From: Laura Gibbons <Laura.Gibbons@arun.gov.uk>
Sent: 21 December 2021 11:37
To: Planning.Responses <Planning.Responses@arun.gov.uk>
Cc: David Easton <David.Easton@arun.gov.uk>
Subject: RE: Planning Consultation on: P/167/21/RES

Engineers Comments Regarding Surface Water Drainage

Application No: P/167/21/RES
Registered: 22nd November 2021
Site Address: Land South of Summer Lane and West of Pagham Road Pagham
Grid Reference: 488747 98017
Category: Plan Applicat'n
Description of Works: Approval of reserved matters (appearance, layout, landscaping and scale) following outline planning permission P/140/16/OUT for the erection of 375no. dwellings, together with public open space, play space, drainage, parking and associated infrastructure, landscape, ancillary and site preparation works, with access off Pagham Road (alternative to P/153/21/RES). This site may affect a Public Right of Way.

Drawing Status		PLANNING	
Client		Foreman Homes	
Project		Land at Summer Lane Pagham, West Sussex	
Drawing Title			
Proposed Levels & Contours (Northern) Sheet 2 of 2			
Scale	Date	Drawn By	Checked By
1:500	Nov 21	DJL	MJA
Drawing No.			Rev.
D1915-203			B

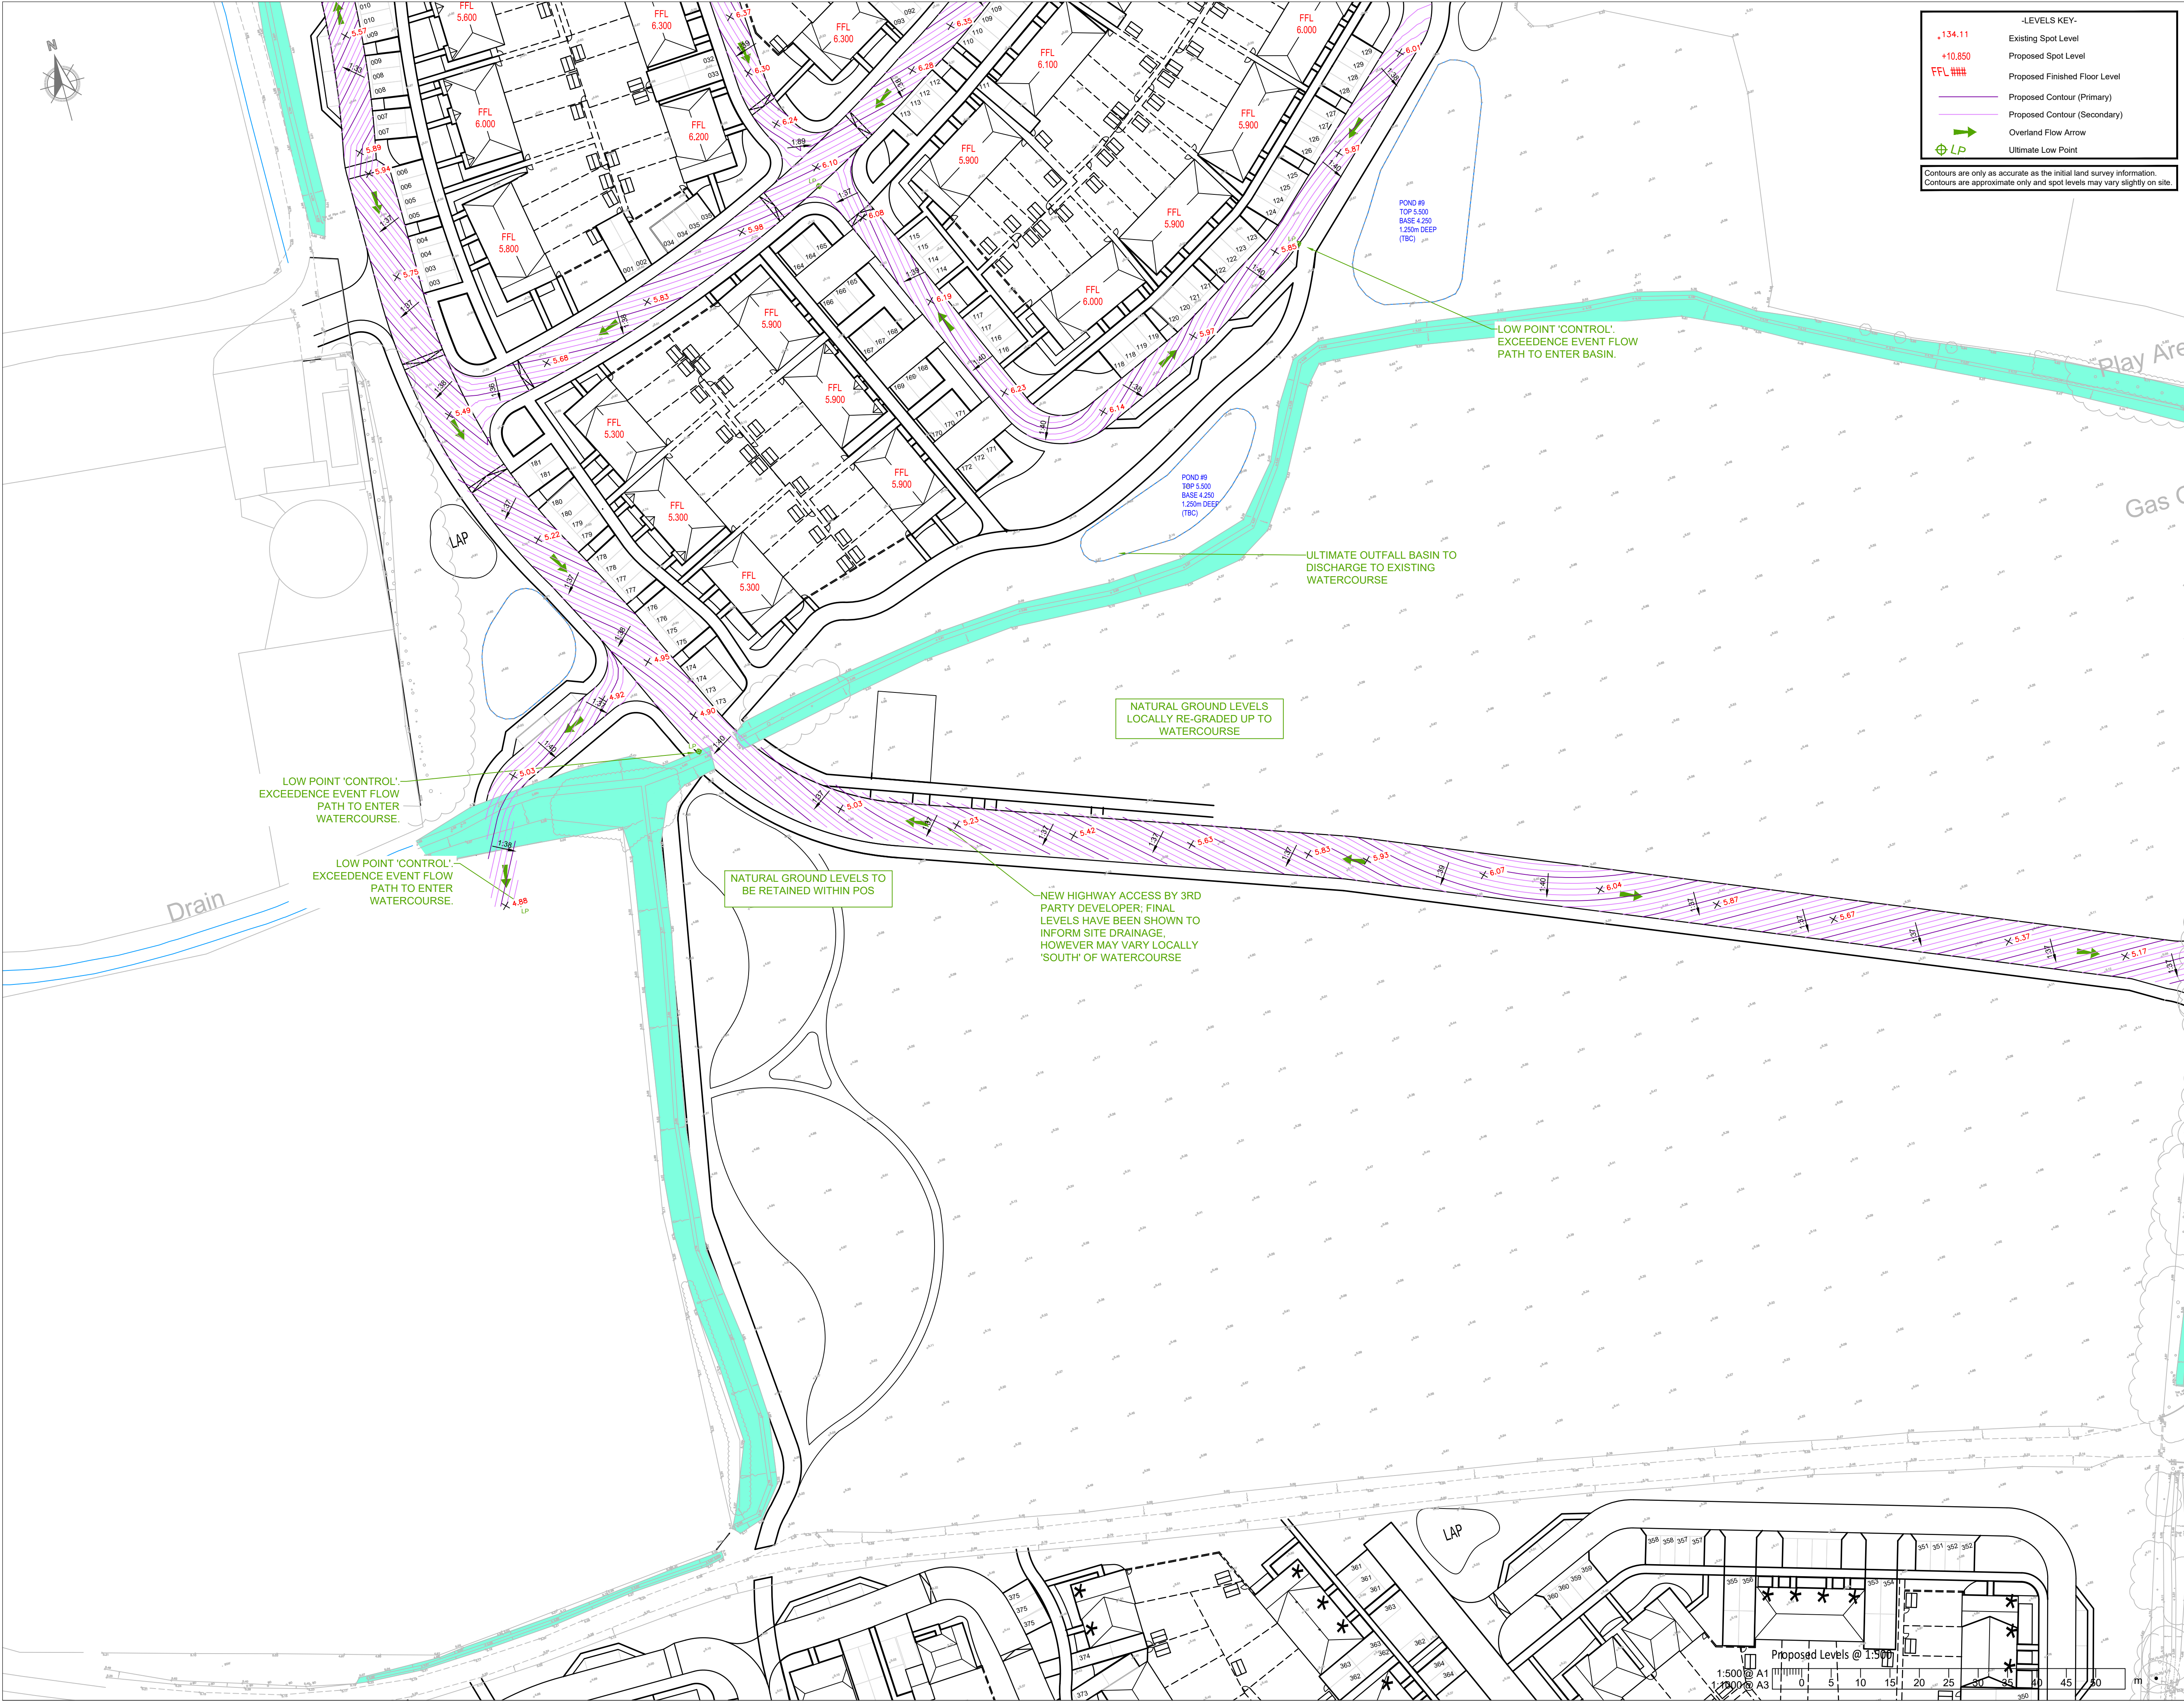
2. Significant ground raising is proposed as part of the development, with some areas proposed to be raised by over 1.5m. We would strongly recommend that the planning officer reviews proposed levels.
